Our ref: DOC20/1008608-4  
Your ref: SSD-10325

### **New Request for Advice - Kincoppal- Rose Bay School – EIS (SSD 10325)**

### **Aboriginal Cultural Heritage Regulation Review of EIS, Aboriginal Cultural Heritage Assessment Report**

Figure 2. The locations of the proposed ground disturbance (yellow hatching) in the three precincts within the western campus

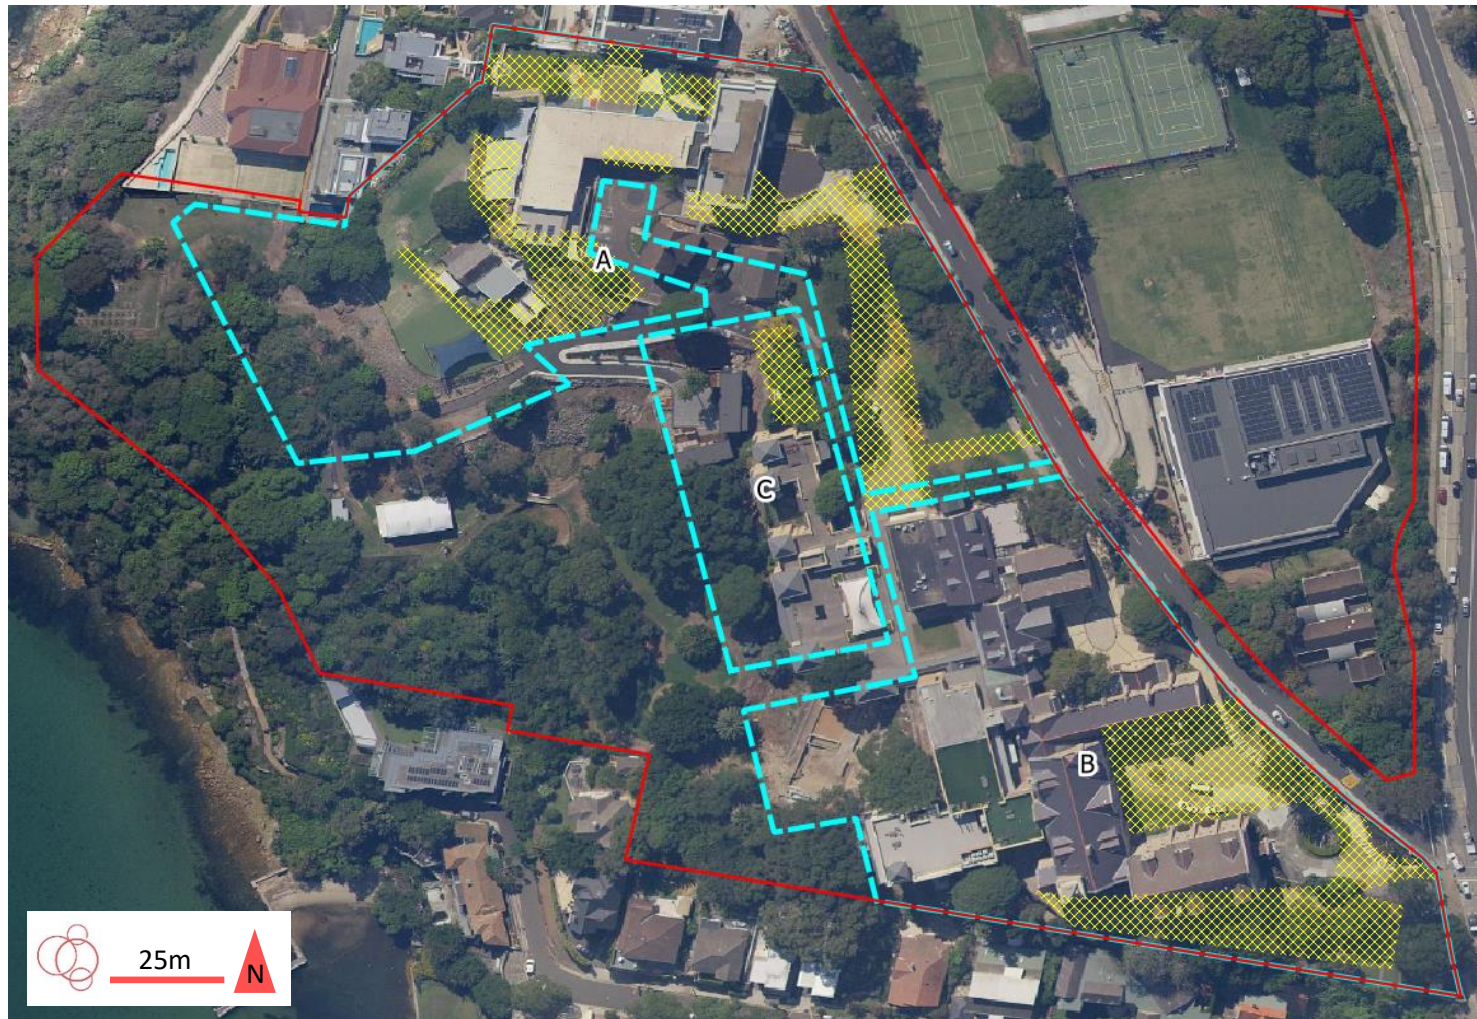
- Clarification should be sought regarding the exact extent and depth of proposed impacts. Additionally, confirmation on whether any ground disturbance is proposed for the early learning centre – Additional Carparking as shown in Figure 6 of the EIS (Umwelt 2020) and whether this impact has been assessed by the ACHAR is needed.
